**RE: SSD 7462 – Minto Recycling Pty Ltd (Bingo Industries)  
No. 13 Pembury Road, Minto**

I refer to the Department's correspondence regarding the proposal to increase the permitted tonnage of waste per annum permitted to be handled at the subject site from its current 30,000 tonnes.

This response has been prepared following receipt of amended information from the proponent, which was prepared in response to submissions raised during the application's public exhibition.

Client: Skyline Properties Pty Ltd.
Project Name: MINTO SSD
Drawing Title: GROUND FLOOR PLAN

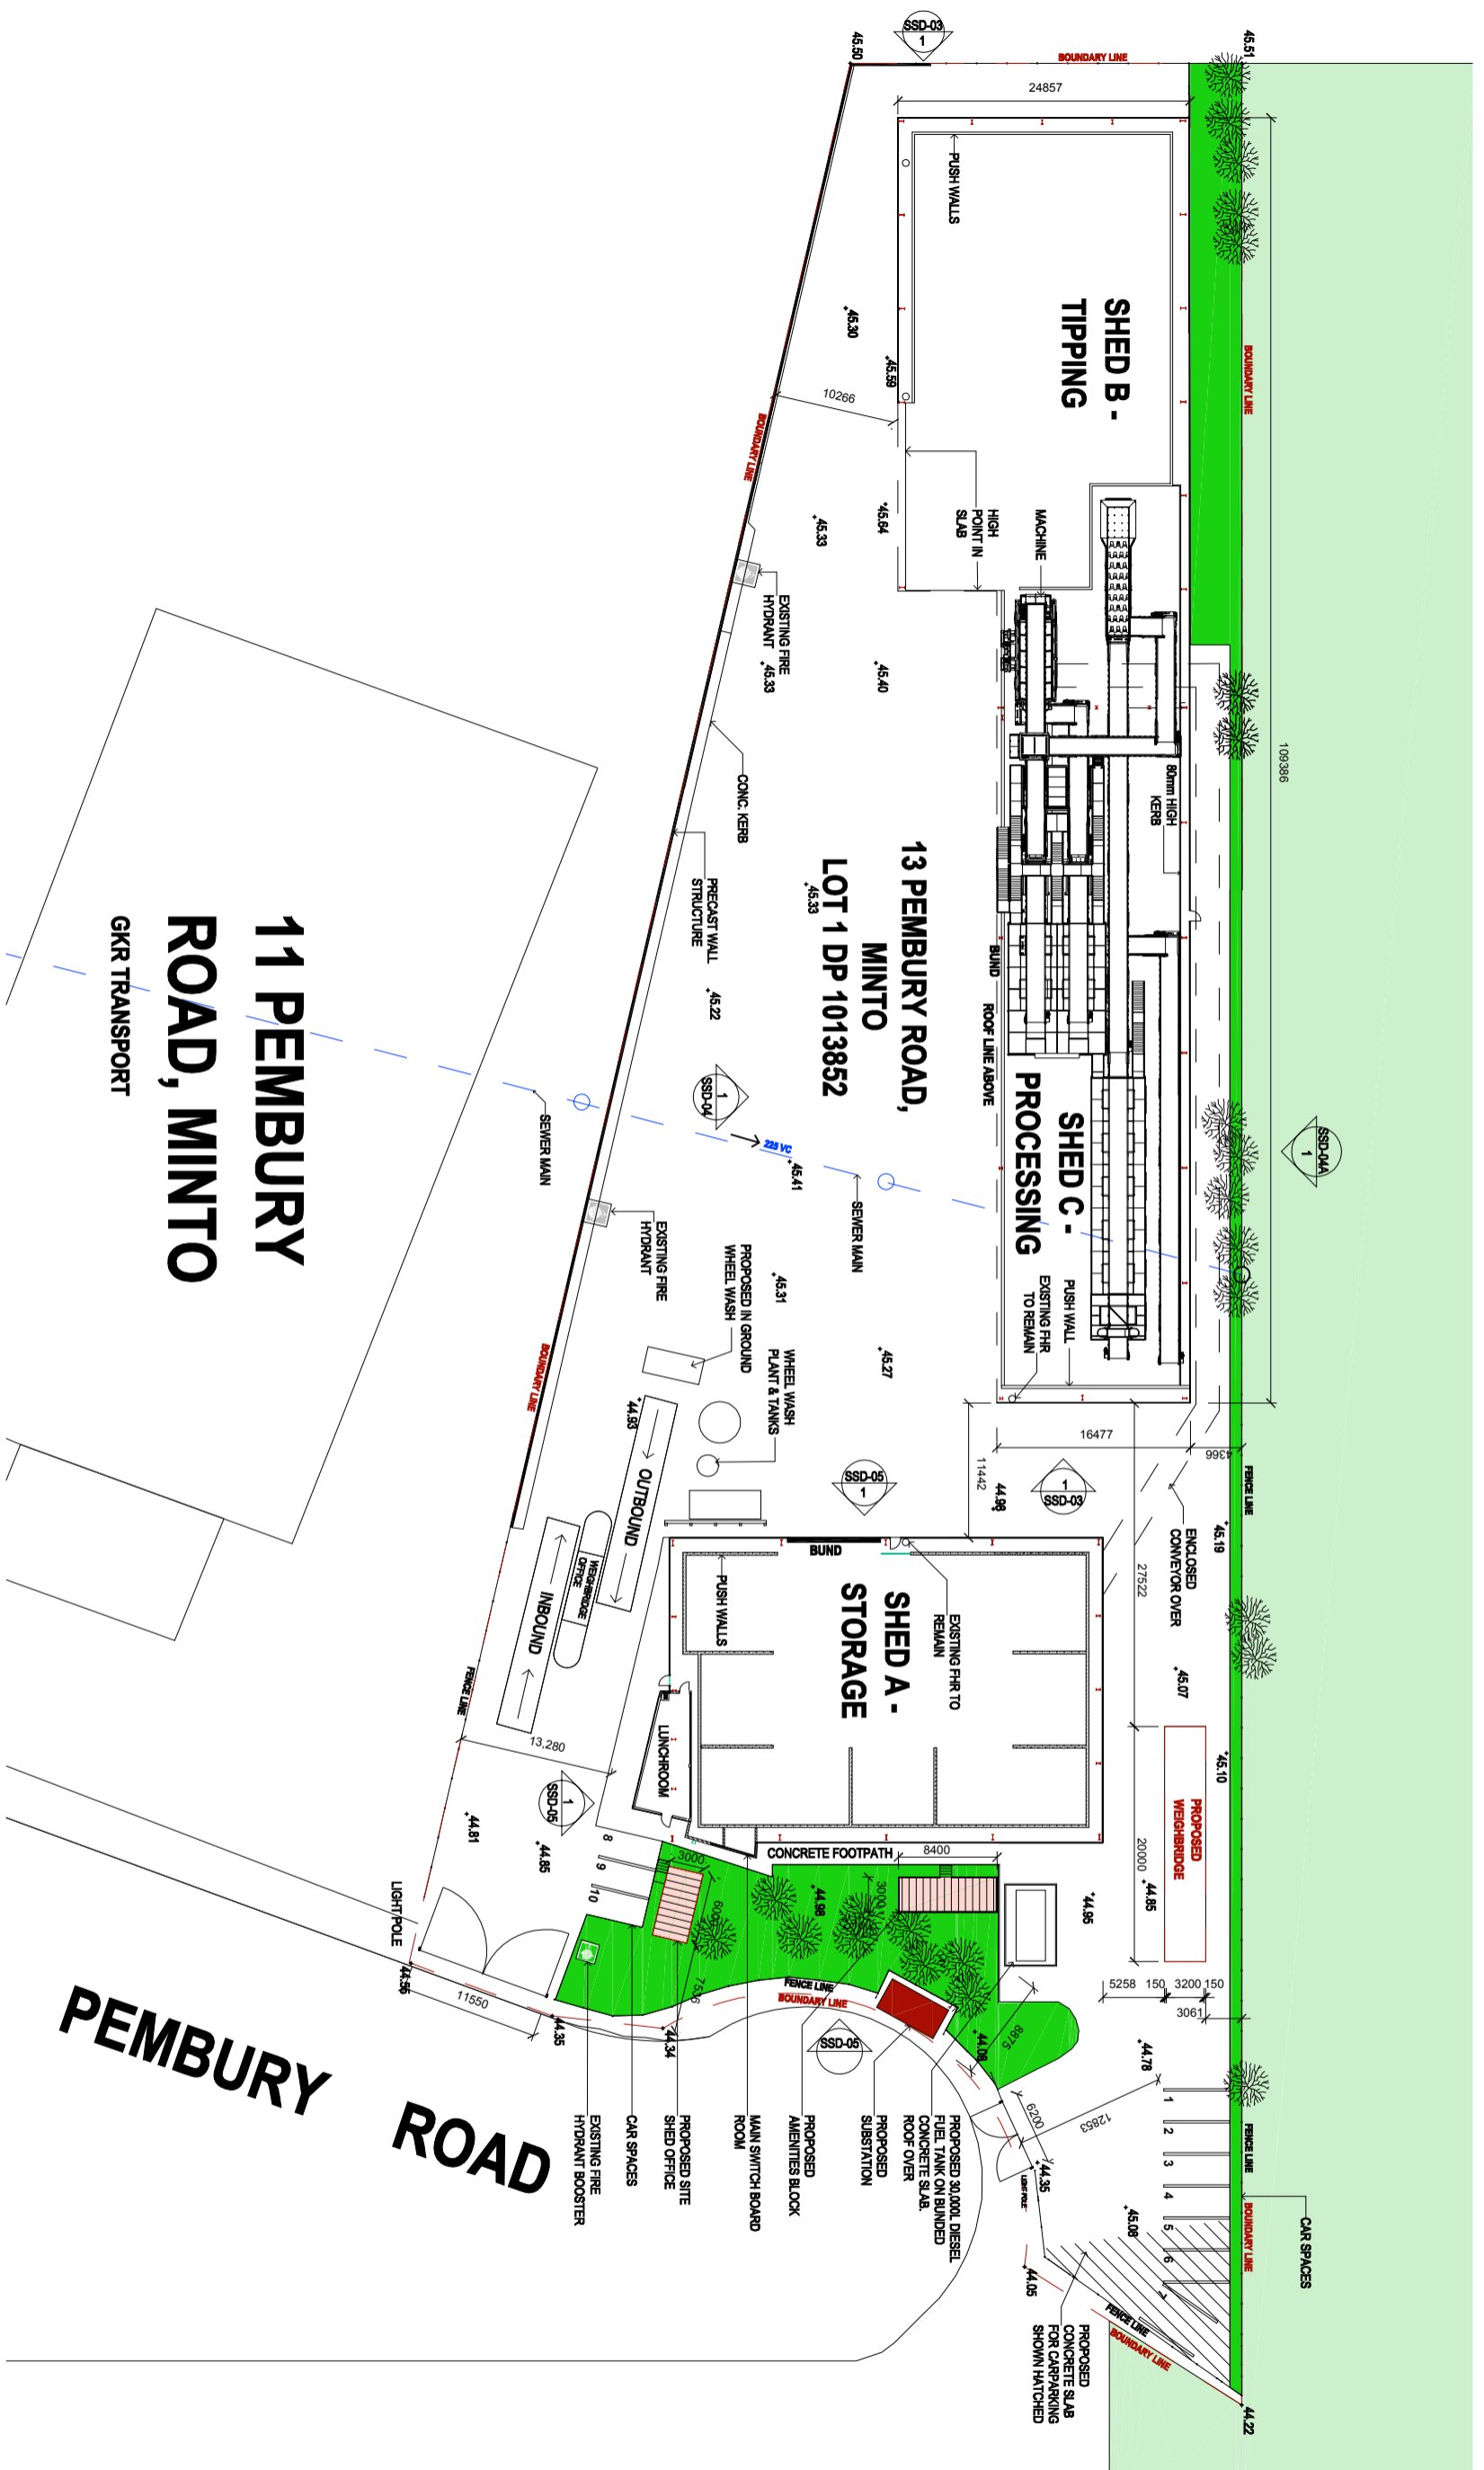
Further, stacked car parking is not permitted under the DCP and the practicalities of that stacking, when coupled with the low number of spaces and shift change over times have not been adequately considered in the proposal. The movement of staff to their vehicles has the potential to interfere with the smooth running of unloading practices within the main building.

The setback of the site office does not comply with Council's development control plan.

Council requests that the Department consider the site's relatively low order landscaping and requests that consideration be given to requiring that it be embellished should approval for this application be granted. There is no accounting made for the loss of existing vegetation should proposed car parking spaces 4 to 7 be constructed.
